From: Anita Gardner
Sent: 15 July 2019 17:45
To: Planning.Responses <Planning.Responses@arun.gov.uk>
Subject: FW: Application Ref: LU/164/19/PL - 5 Arundel Road, Littlehampton

Environmental Health: I acknowledge information already provided in the Planning Statement, dated May 2019, Ref 13538. I now refer to that Noise Assessment, Job Number A113884, 3rd Issue, prepared by Wyg.

Studio Lack Architecture Studio Lack Ltd : 17 Beech Avenue : Chichester 01243 782 686 : nicholas.lack@live.com : PO19 3DR	5 Arundel Road, Littlehampton	Block/Site Plan 28/03/19 1/500 @ A4	Dwg 1915-03C
--	---	---	-------------------------

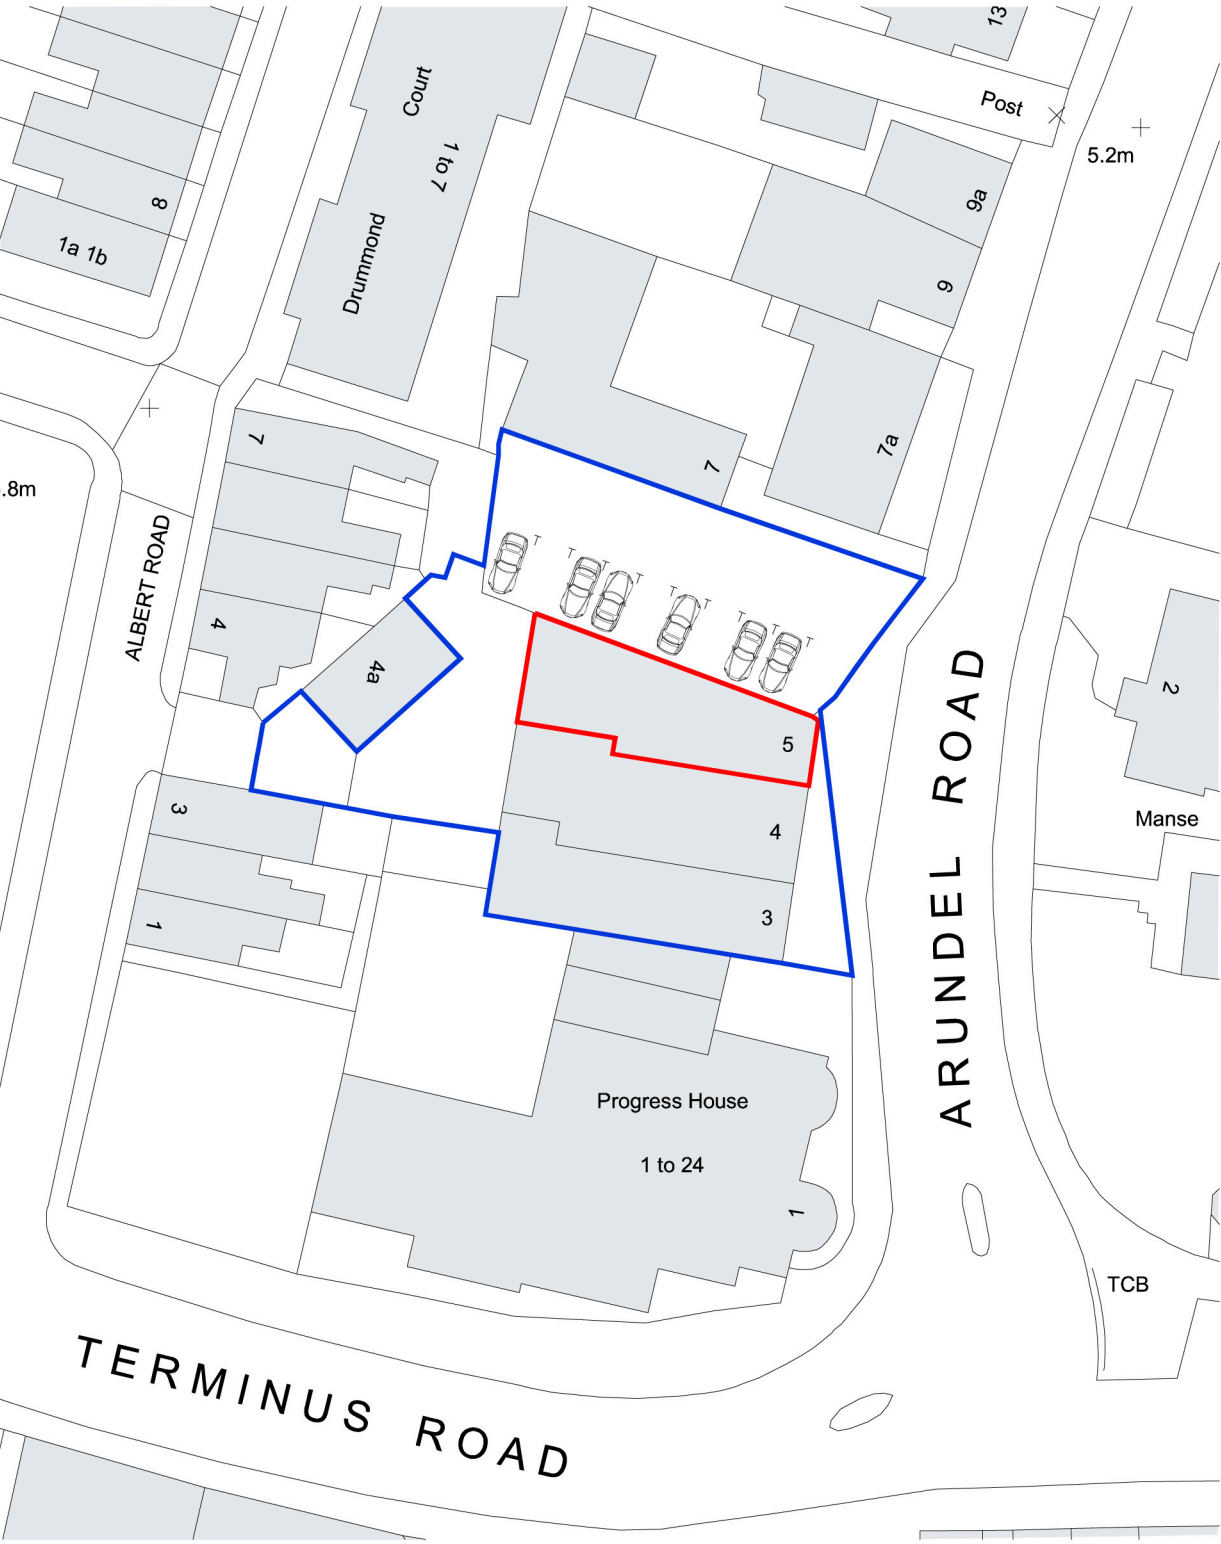
In respect of car parking, the acoustic report needs to be expanded to properly describe the acknowledged intensification of use of this space, ie the number of customer as well as the number of delivery vehicles and the type of delivery vehicles such as mopeds, etc which will arrive at/depart from this site over a given time during proposed operating hours and how this will affect the acoustic environment, particularly of sensitive receptors R5 to R10 and mitigation measures that may be necessary.

Studio Lack Architecture Studio Lack Ltd : 17 Beech Avenue : Chichester 01243 782 686 : nicholas.lack@live.com : PO19 3DR	5 Arundel Road, Littlehampton	Proposed Elevations 30/03/19 1/100 @ A3	Dwg 1915-07C
--	--	---	---------------------

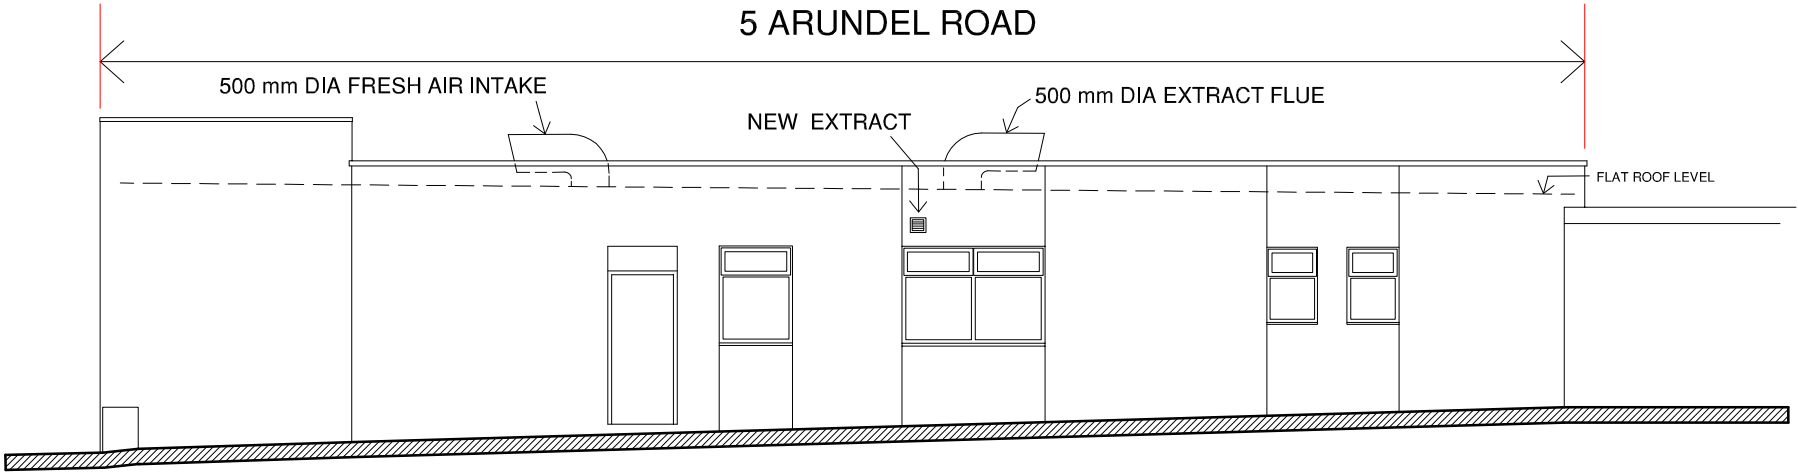
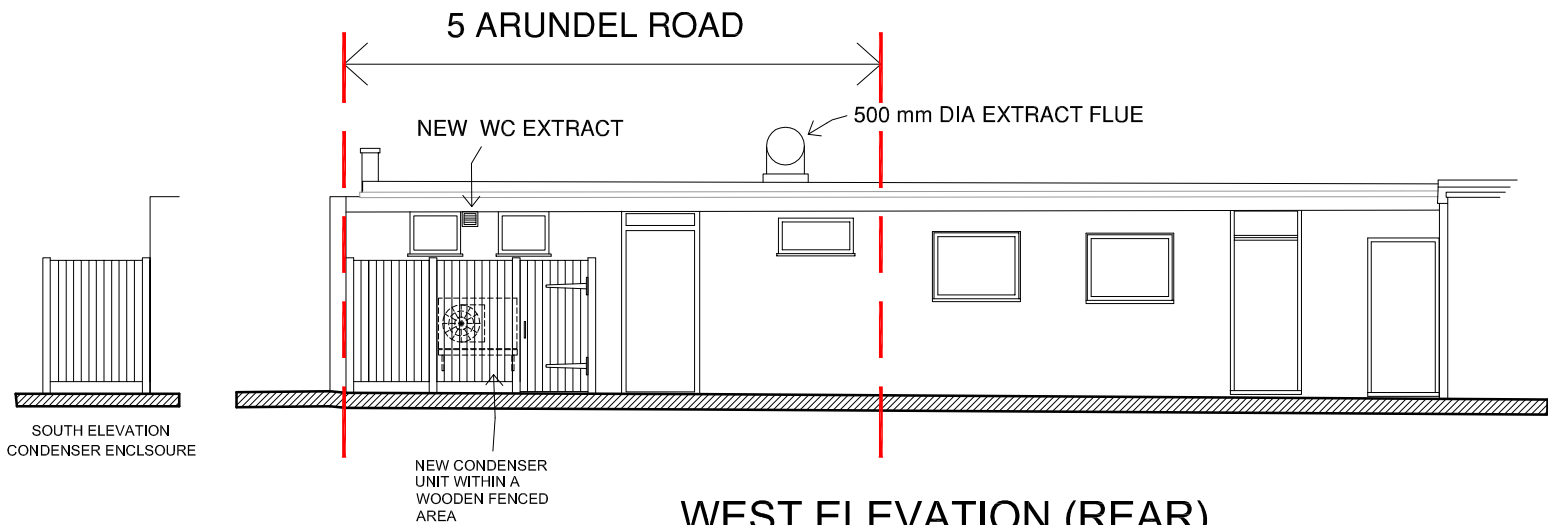
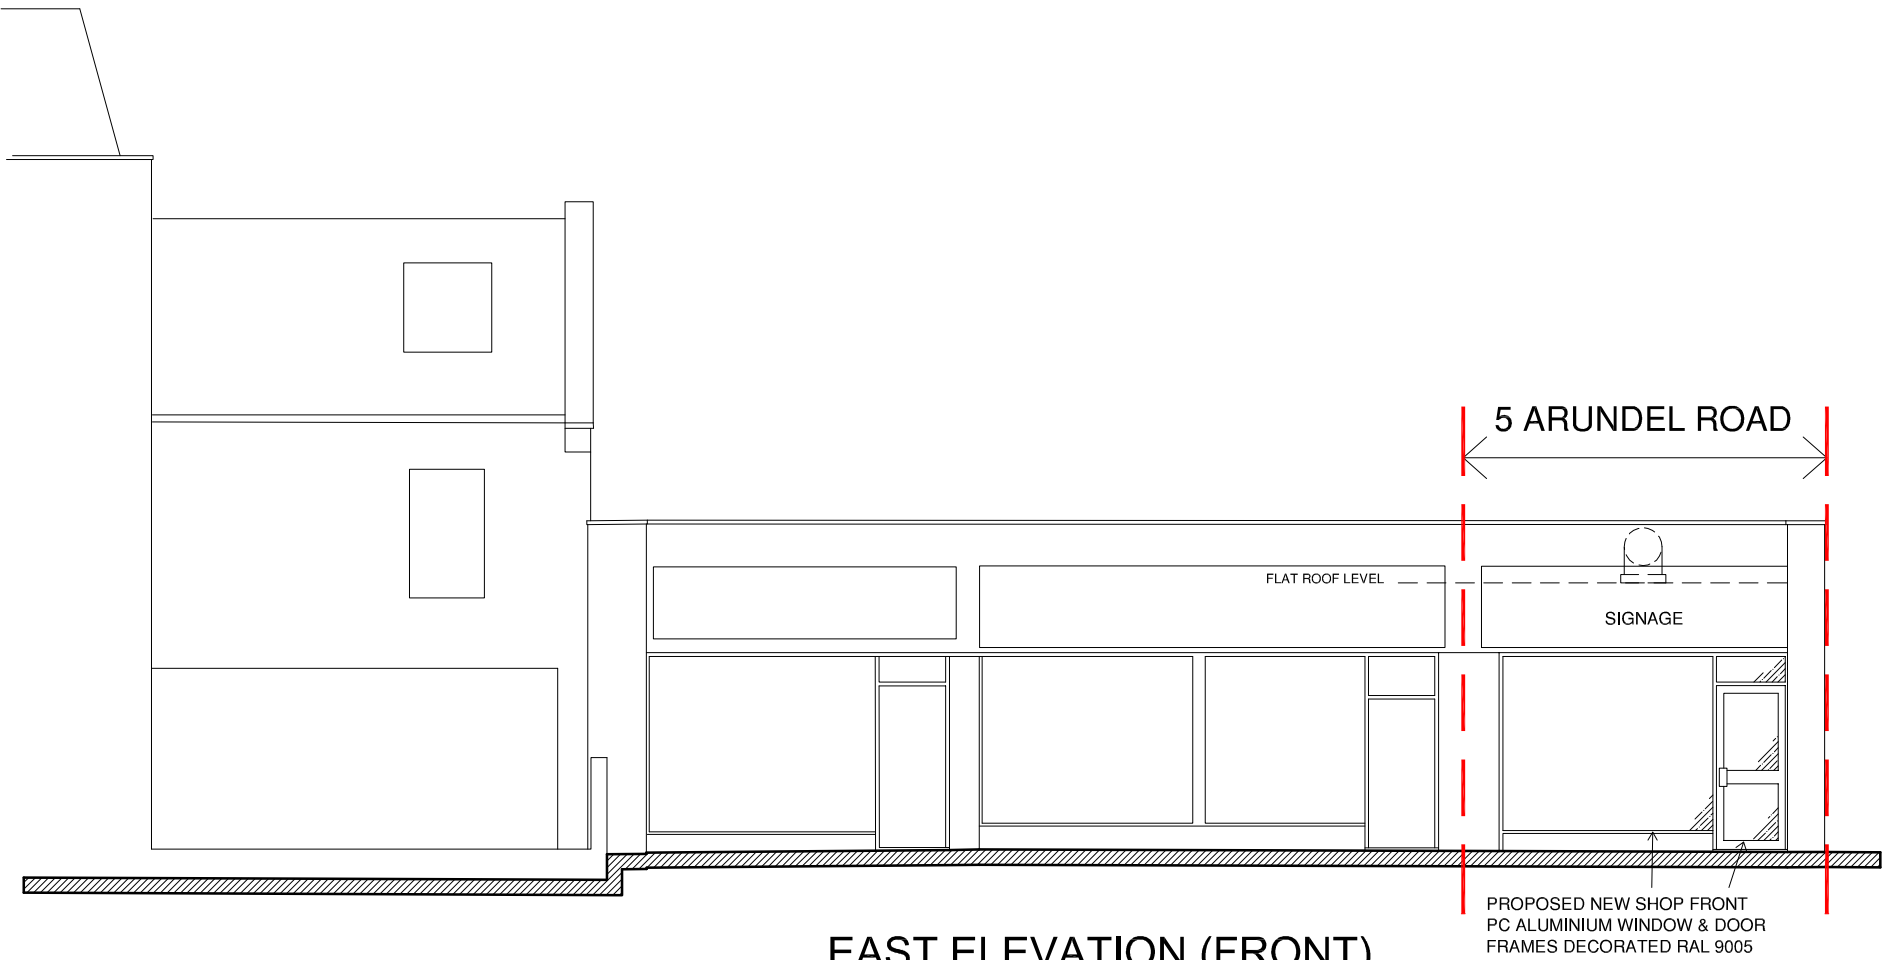
Unfortunately this report only considers noise from the condenser unit to the walk in chiller, whilst excluding other new noise sources particularly in respect of noise from the air intake and exit flue to the flat roof of this single storey building above the kitchen odour abatement system, but also extract ventilation to the kitchen sinks. Please would you request that the applicant also provides proper assessment of these areas, together with detail of any further mitigation measures that may be necessary

Odour Assessment: See Wyg Job Reference Number A113884, 4th Issue, 18th June 2019 and Defra Guidance on the Control of Odour and Noise from Commercial Kitchen Exhaust Systems, 2018. The proposed flue will discharge to the roof of this single storey business where it is surrounded by higher levels domestic residences. For this reason then I would dispute a dispersion Score of '10 – Moderate' instead applying the Rating '20 – Very poor,' particularly since this faces sensitive rooms of that home to the immediate north of the development. I would also Rate the size of this kitchen as 'Medium – 5 rather than Small – 1' and the type of cooking as '4 – Medium.' I agree with the Rating of 10 for the proximity of receptors, which leads me to the overall Odour Risk Assessment of 37 and the need for a 'Very High' level of odour control. Alongside baffle filters detailed then specification to be given for the type of prefilter to be provided as well as clarification as to a 0.4 second retention time through the activated carbon filters.
